## **Development Facilitation Team (DFT) – Review Comments**

**Project No: PR-2025-020029   Date: 3/12/2025   Agenda Item: # 1   Zone Atlas Page: H-21**

**Request: Waiver-DHO to the underground installation requirement for a relocation of an existing overhead electric distribution feeder line.**

### **Application For: – DHOWVR-2025-00003 – DHO WAIVER**

Underground Utilities in Public R.O.W.

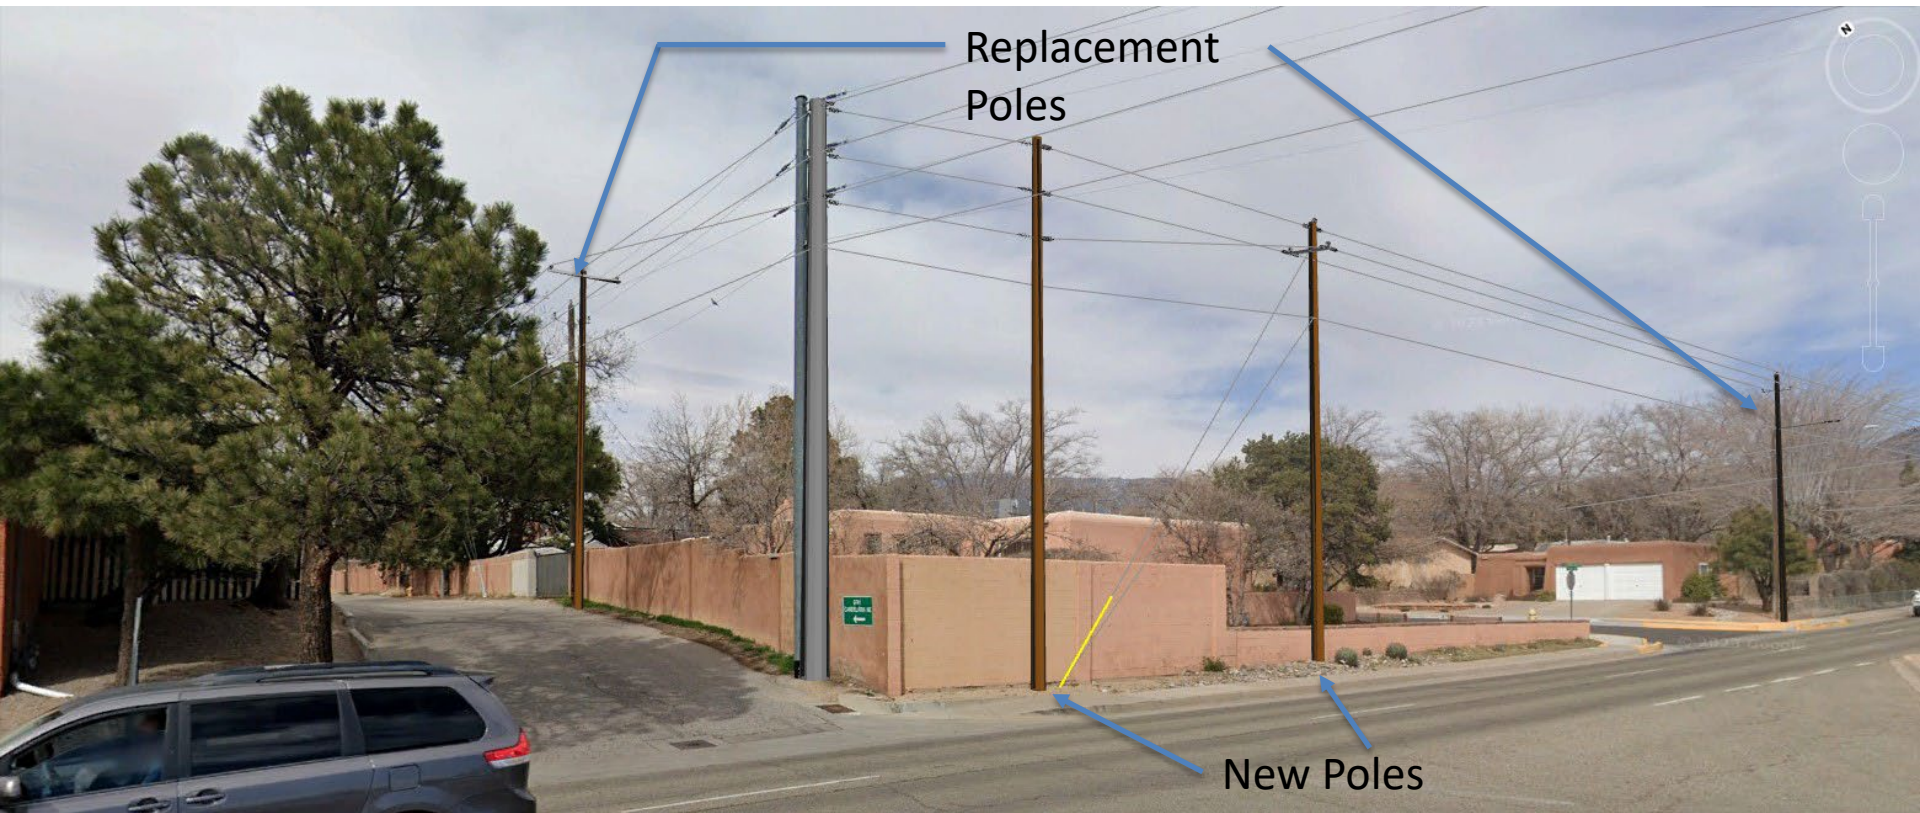
1. No objections.
2. All proposed overhead power poles to be situated along Candelaria Rd are on the opposite side of the underground water and sanitary sewer infrastructure that exist along the southside of Candelaria Rd. In addition, all the proposed overhead power poles between or adjacent to the side streets are not near any of the water and sanitary sewer lines that connect from the side streets onto the main lines in Candelaria Rd.
3. Installation of overhead power poles as opposed to trenching for underground installation is far less intrusive and likely to damage existing underground water, sanitary sewer and storm sewer utilities.

Bloom Street to Britt Street

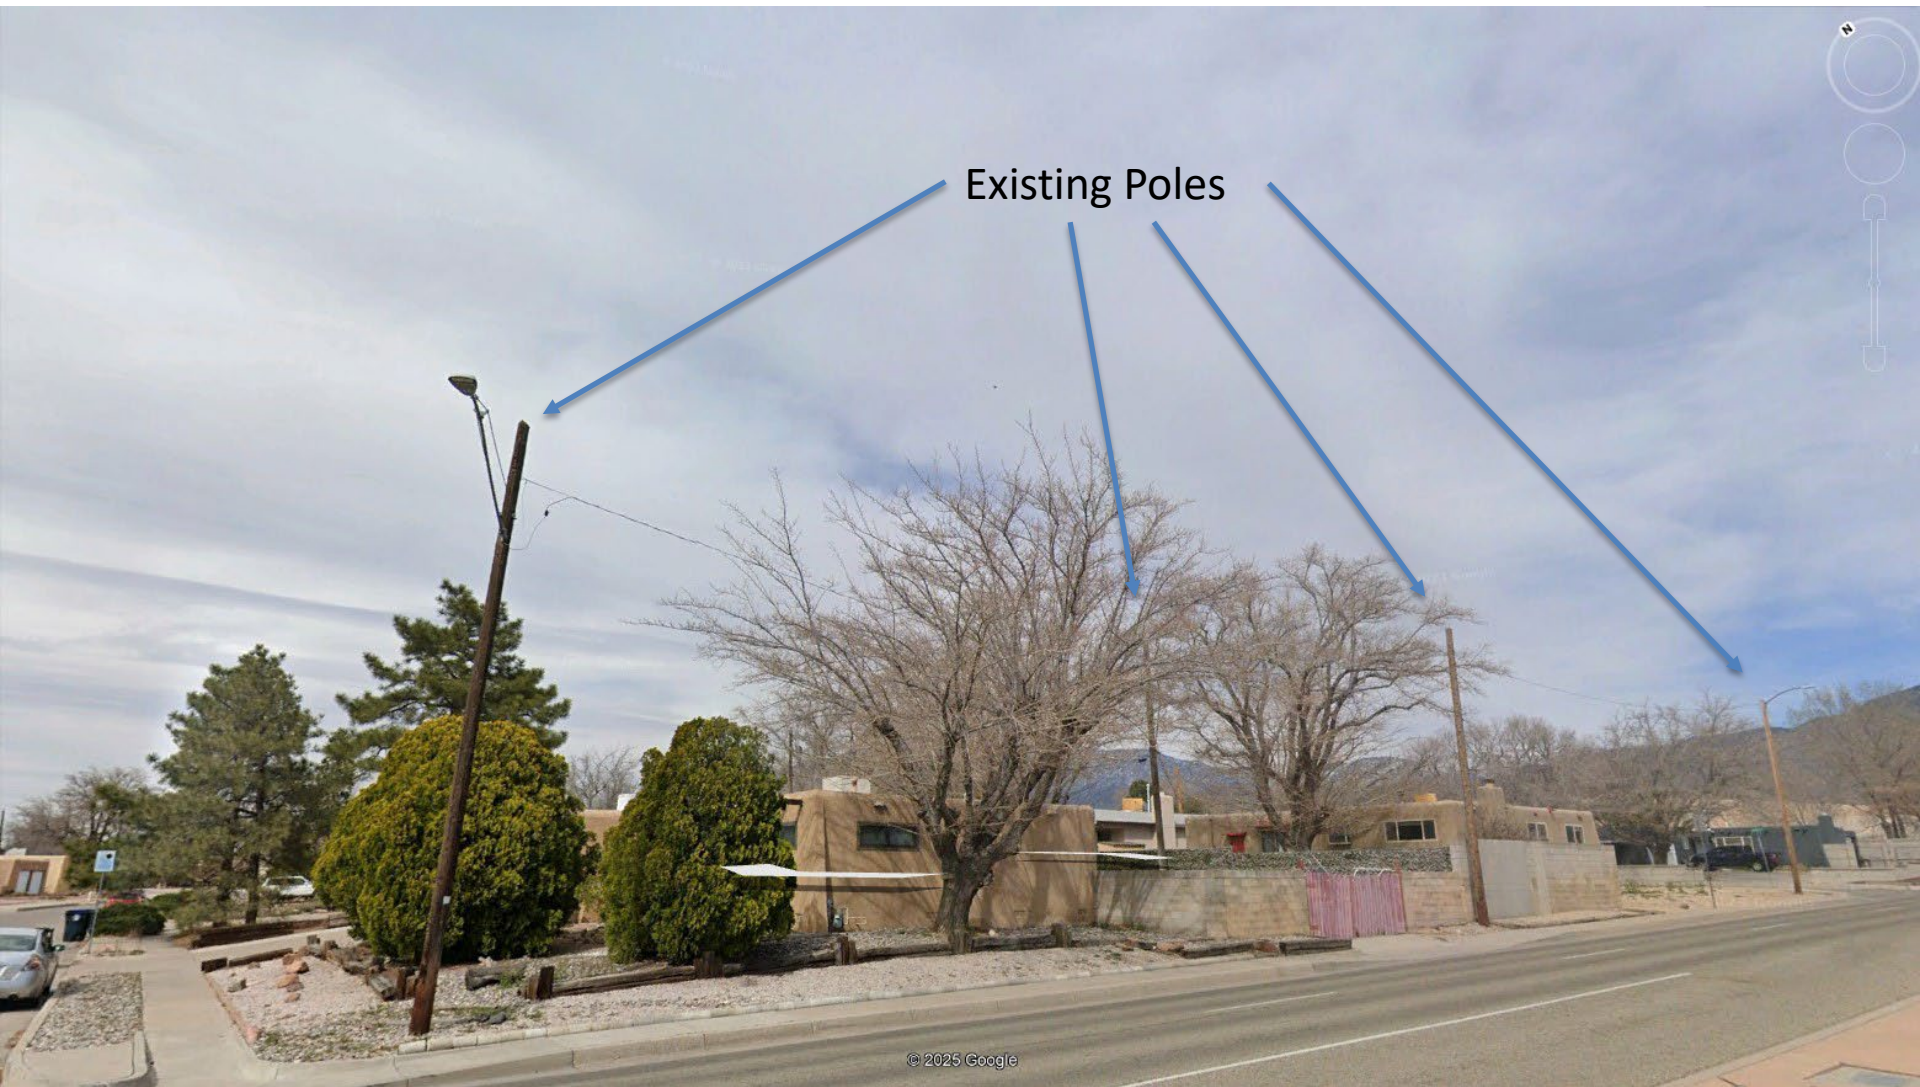
- Although this request seems to meet the specified criteria, the justification provided does not offer enough evidence to explain why certain electrical distribution lines are still running north from the new pole on Candelaria Rd, between Bloom St and Britt St, as well as Betts Dr. The issue with tree obstruction persists and is unlikely to be resolved. \* See Exhibits below

Britt Street to Betts Drive

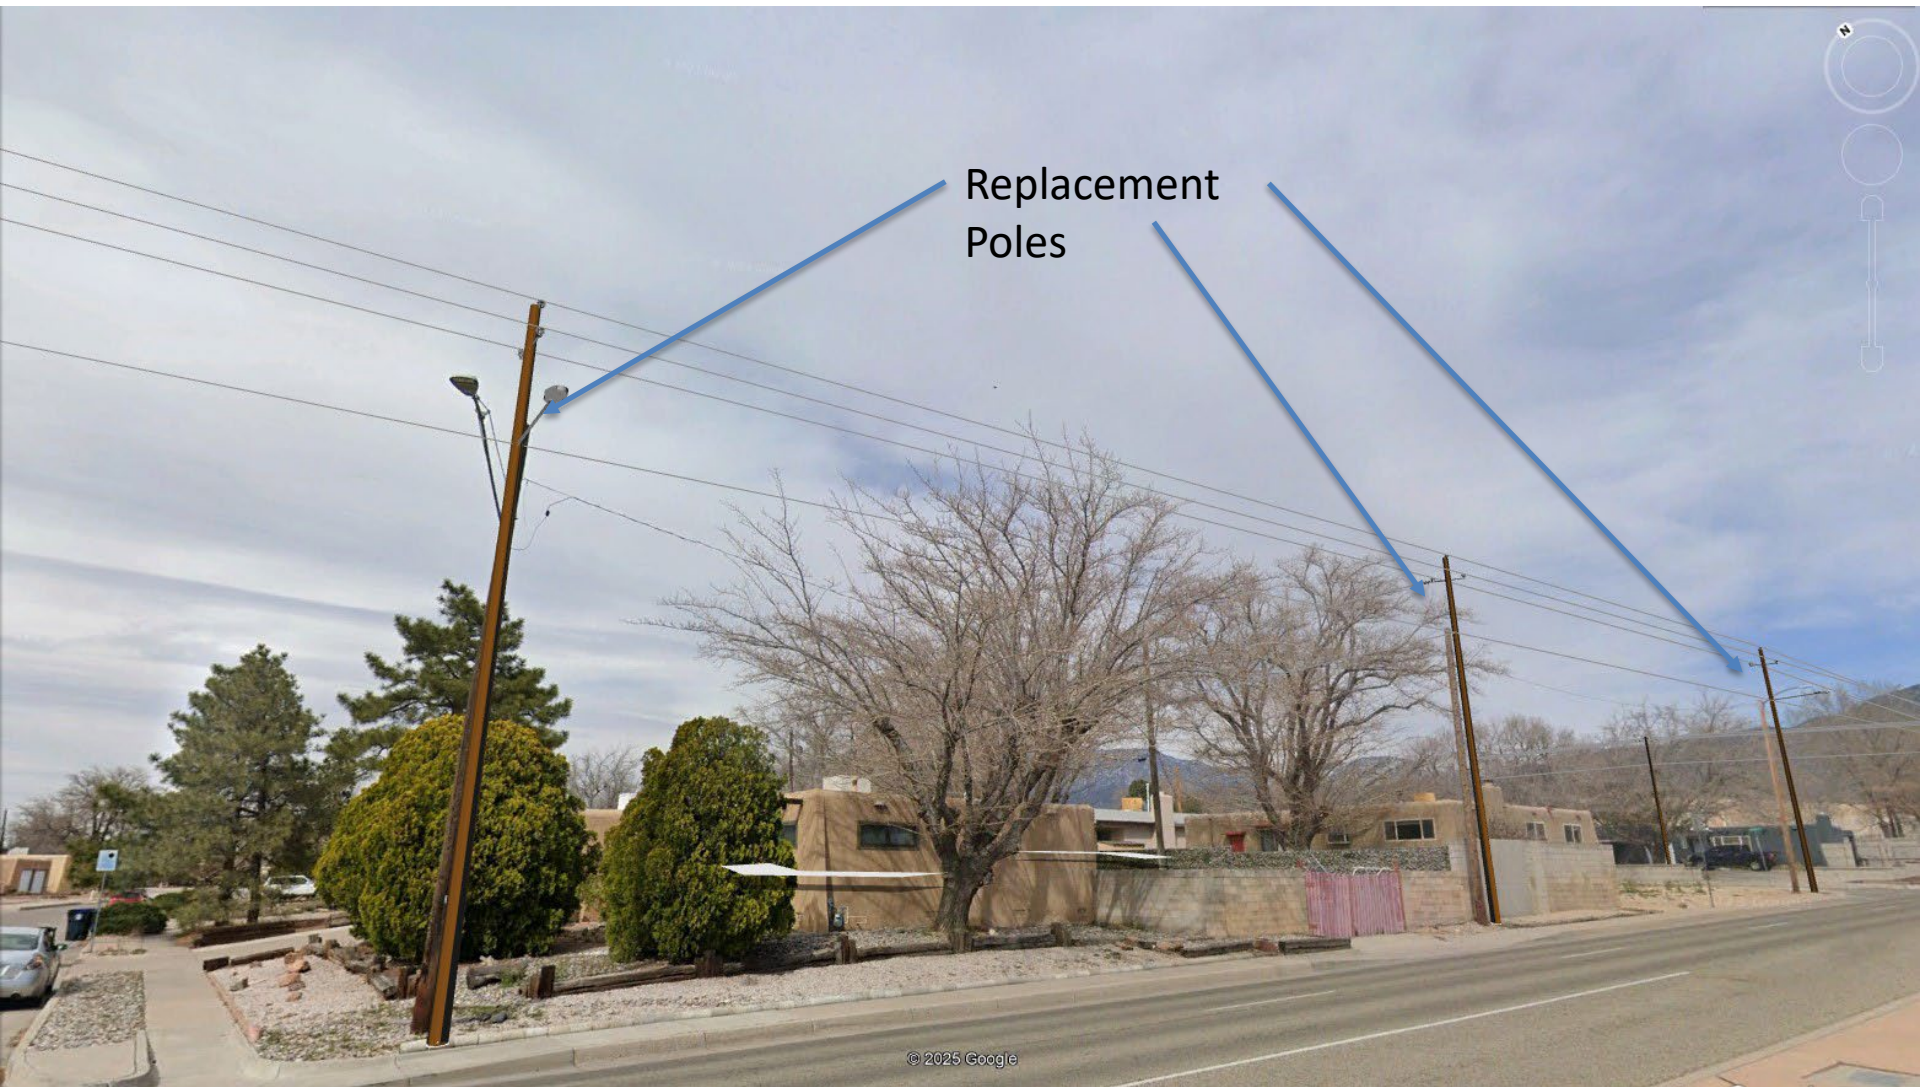
- By removing approximately 750 feet of overhead distribution feeder line from inside the neighborhood, please explain how the northern part of this neighborhood will benefit from the proposed project.
